PLANNING AMENDMENT

Application No. H11/0996/02/A1 (DE)

PROMISED EXTENSION AND WORKS TO REAR OF HOUSE.

Amendment: Garage length increased

PLAN AS PROPOSED

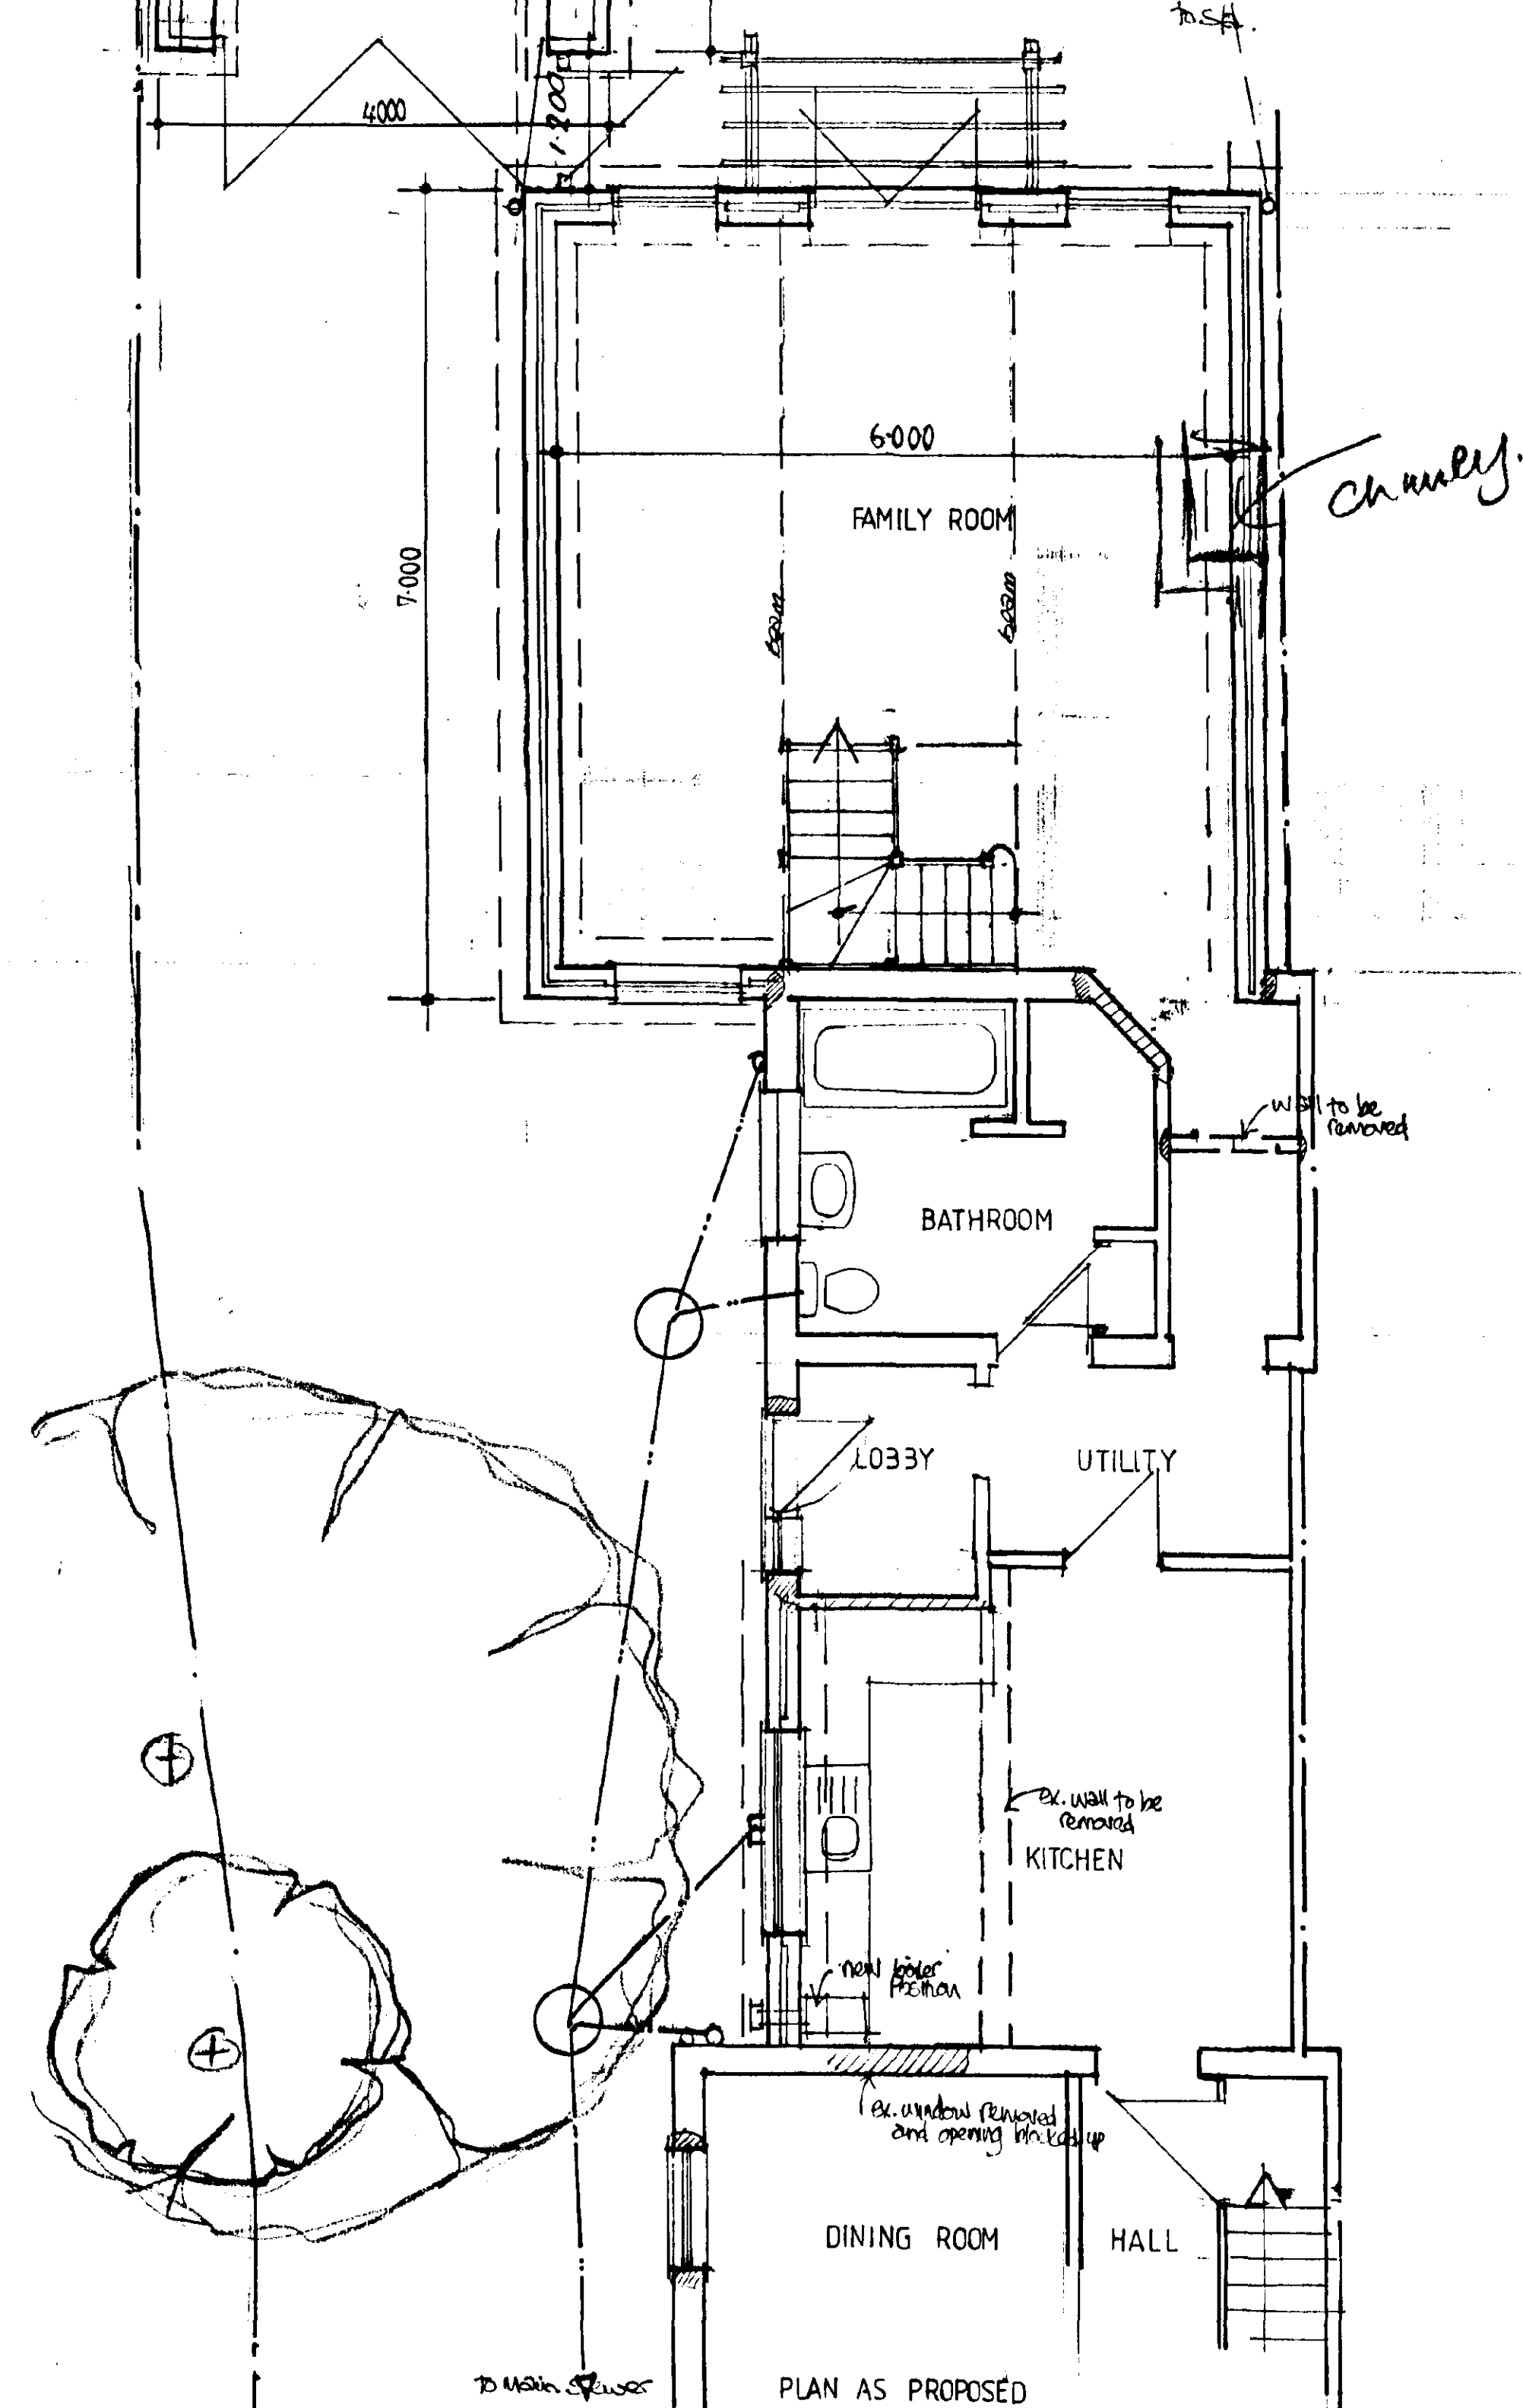
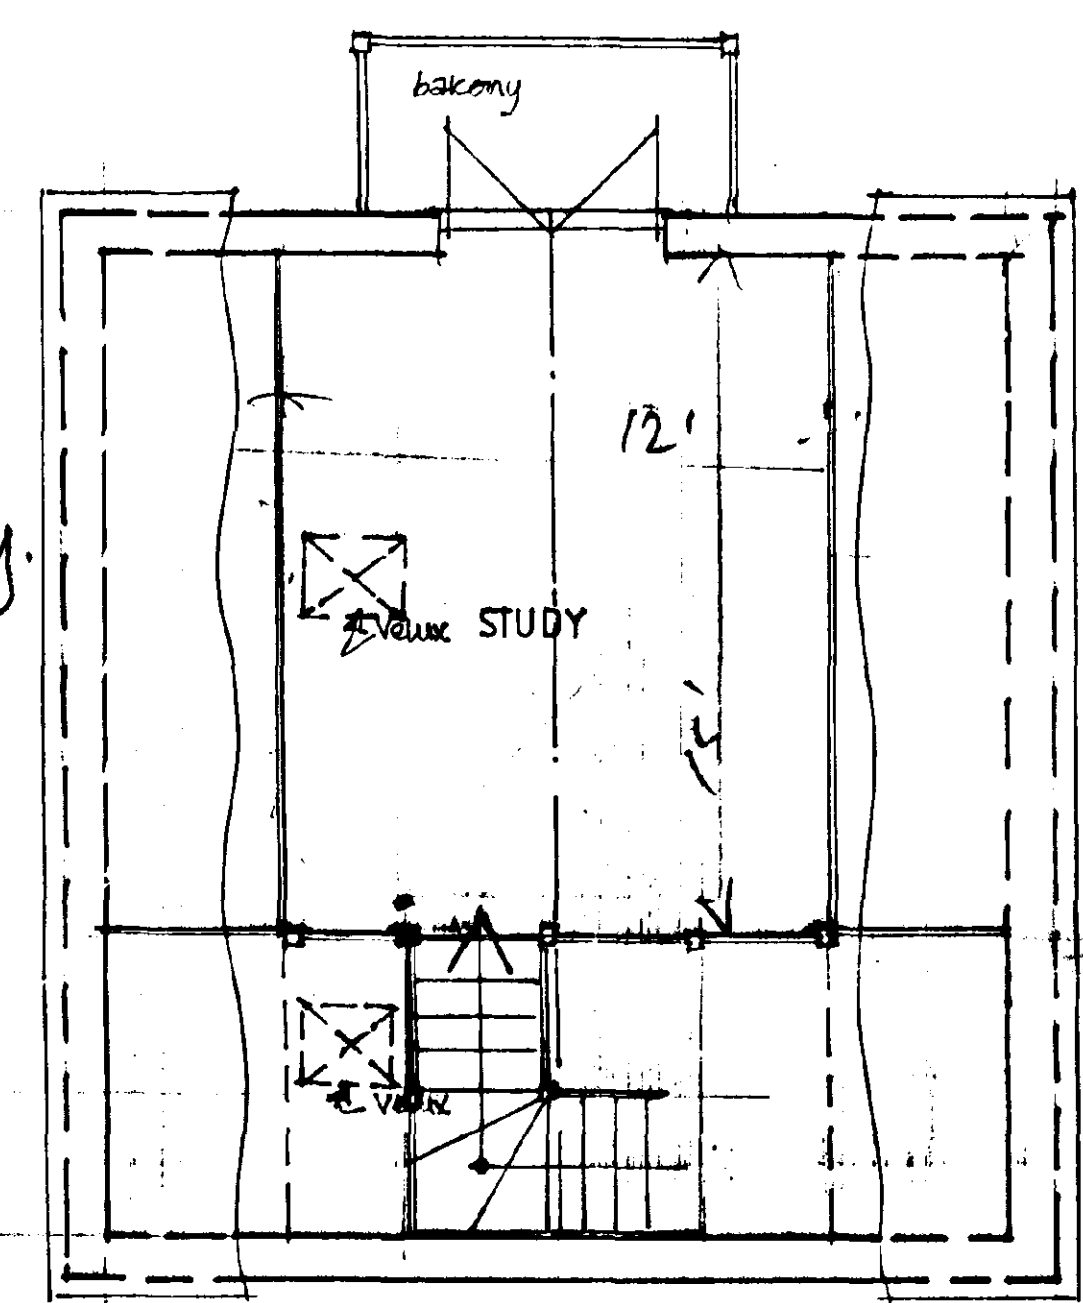
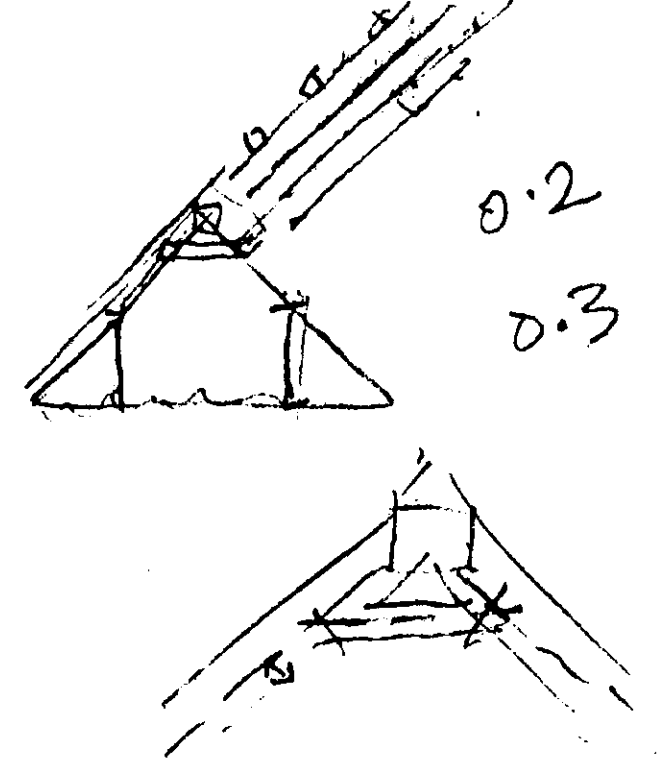
GARAGE LENGTH INCREASED AS DISCUSSED WITH MONICA
